SUMMARY MEMORANDUM

TO: El Paso County Board of County Commissioners
FROM: Planning & Community Development
DATE: 6/13/2024
RE: MS234 Guntzelman Porcelain Pines Minor Subdivision

A request by Christa and Kristian Guntzelman for approval of a 35.06-acre Minor Subdivision creating three (3) single-family lots. The property is zoned R-T (Residential Topographic) and is located at the intersection of Mountain Road and Kulsa Road and is approximately one-quarter of a mile west of Chipita Park Road.

GUNTZELMAN PORCELAIN PINES SUBDIVISION

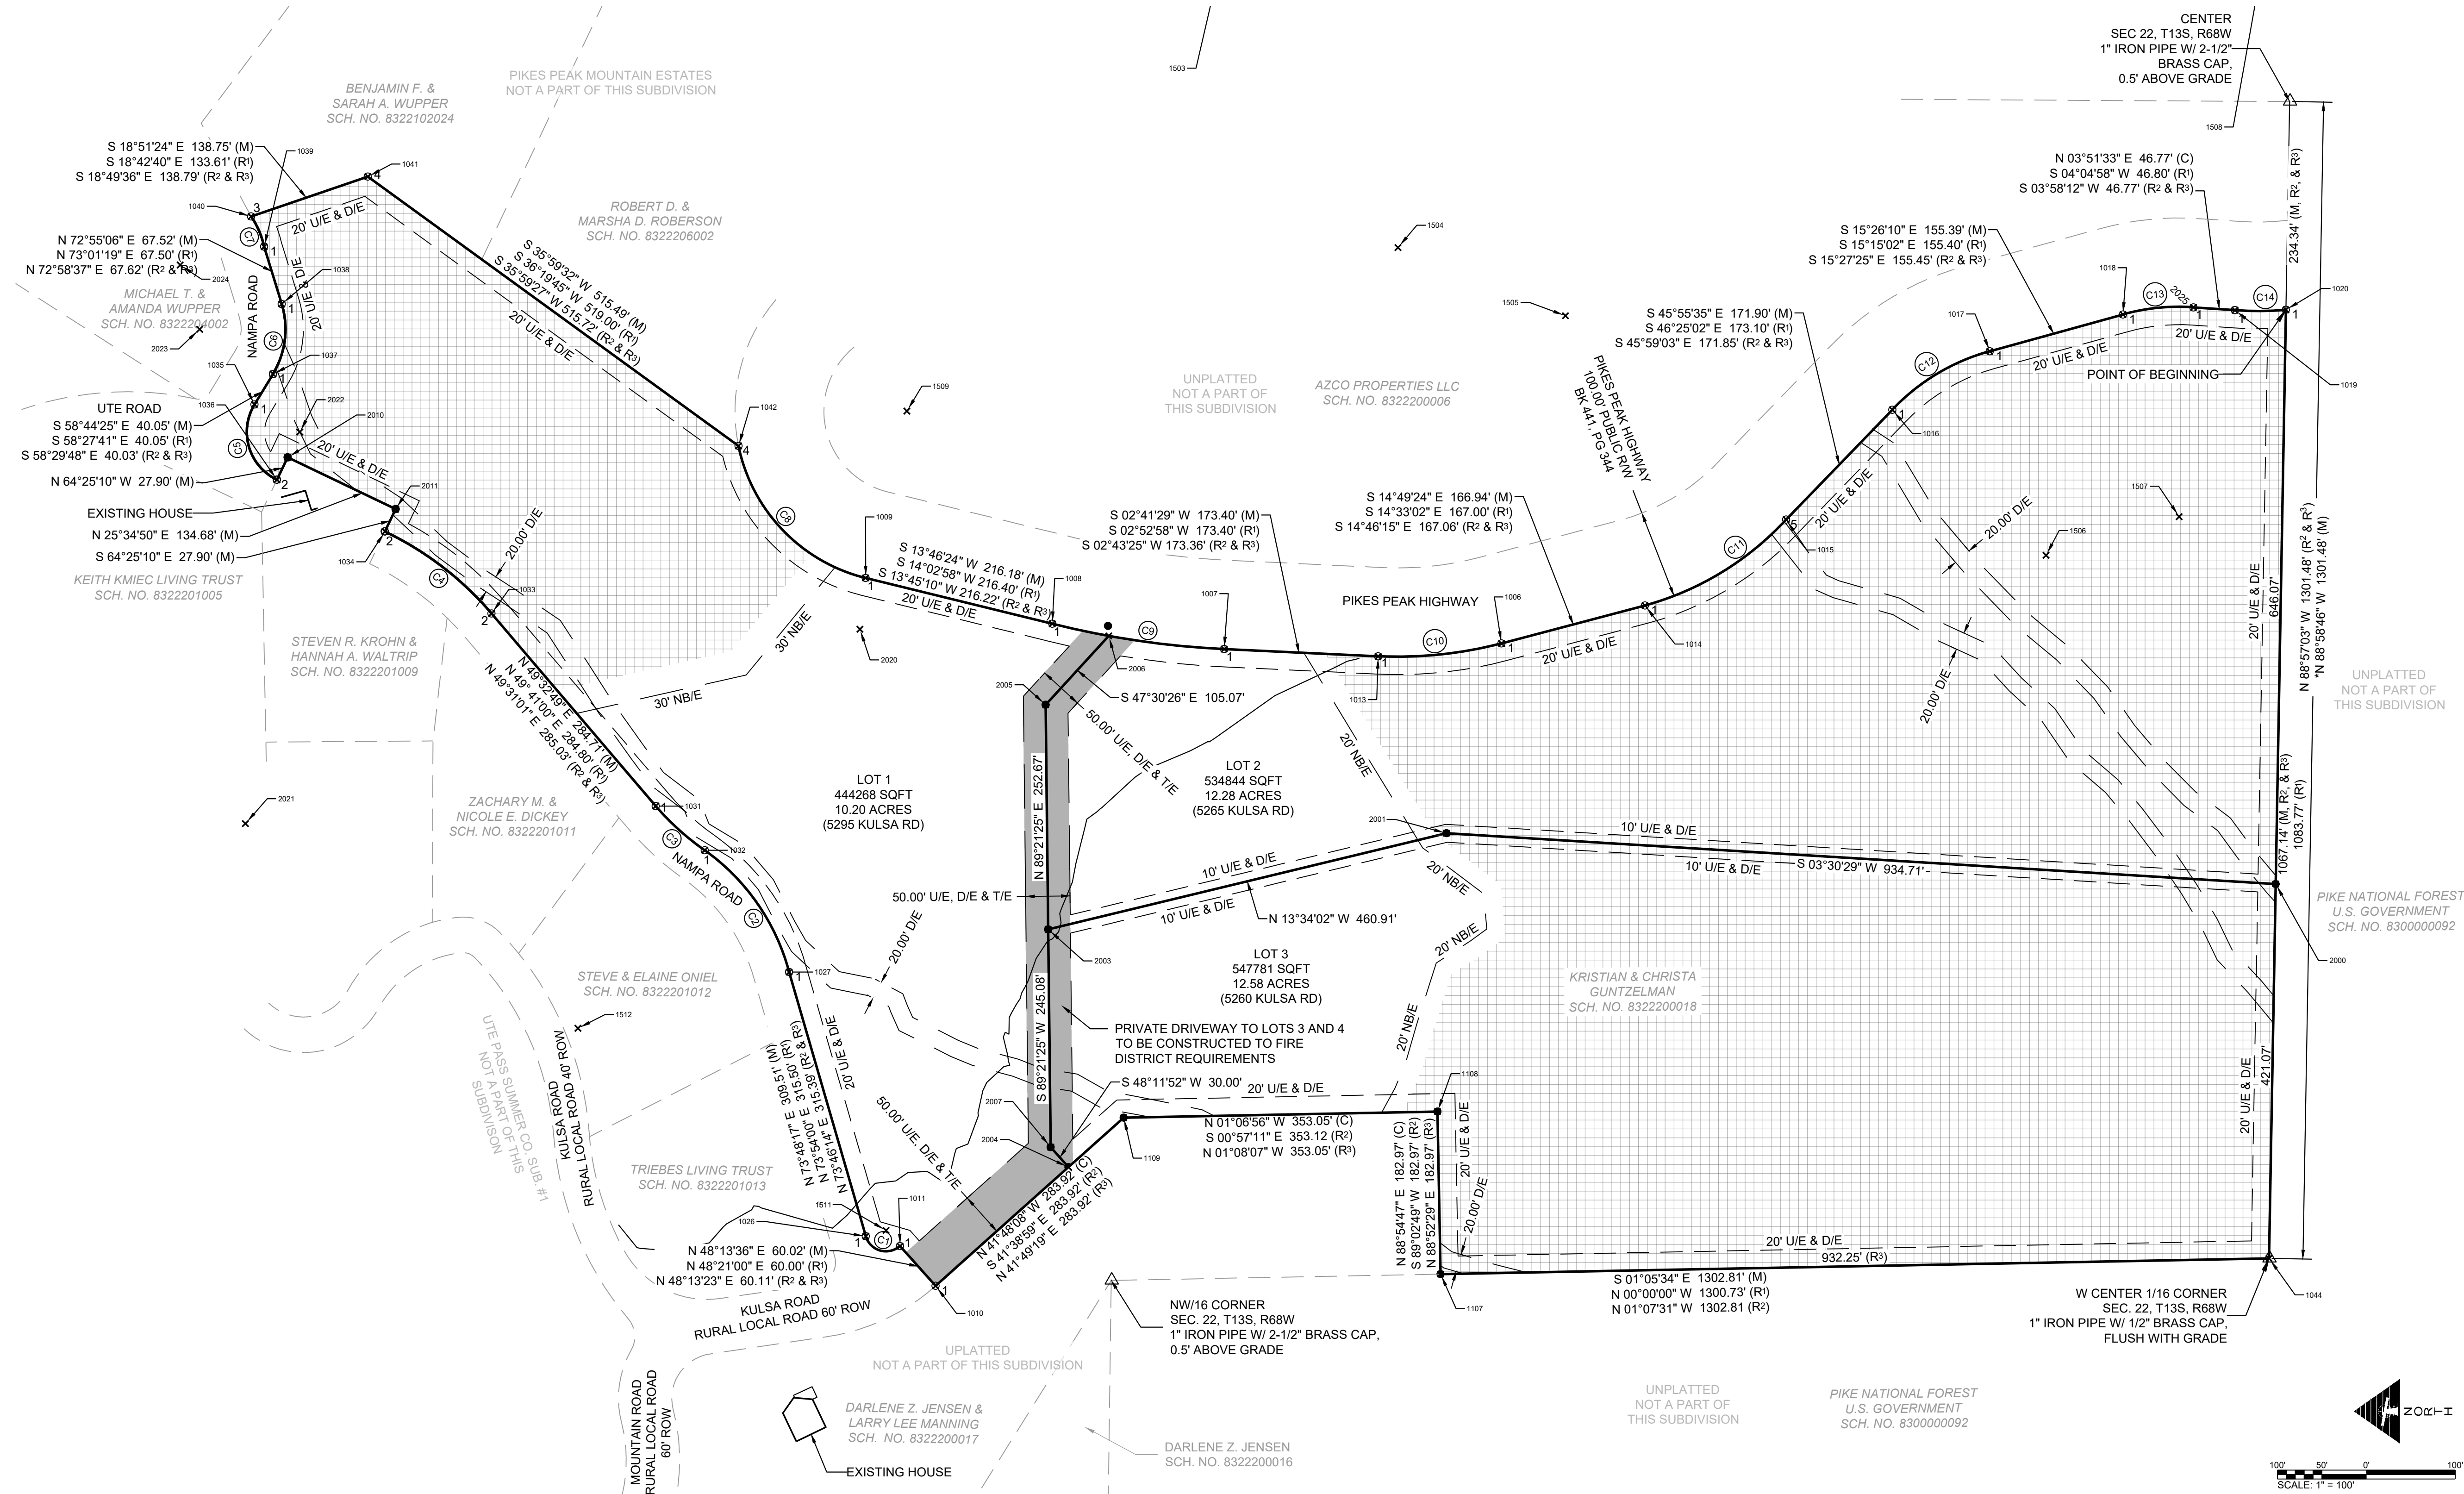
Mr. Howser commented on last-minute agency review comments that were received (and are now part of the EDARP record). It was requested that the lots be platted with a 50-foot no-build buffer along all lot lines that are adjacent to the National Forest. He pulled up an image of the proposal to show that the proposed parcels already have a no-build designation where they are adjacent to National Forest property.

Mr. Carlson asked what was depicted in the bottom right-hand corner of the proposal.

Mr. Whitney asked if it's Mr. Howser's opinion that the request for a no-build buffer along the National Forest is moot since the area already has a no-build designation due to slope.

Mr. Markewich asked if the properties northwest of the subject parcel also had to comply with a 50-foot buffer.

Mr. Howser answered that it is a drainage easement. The presentation continued.
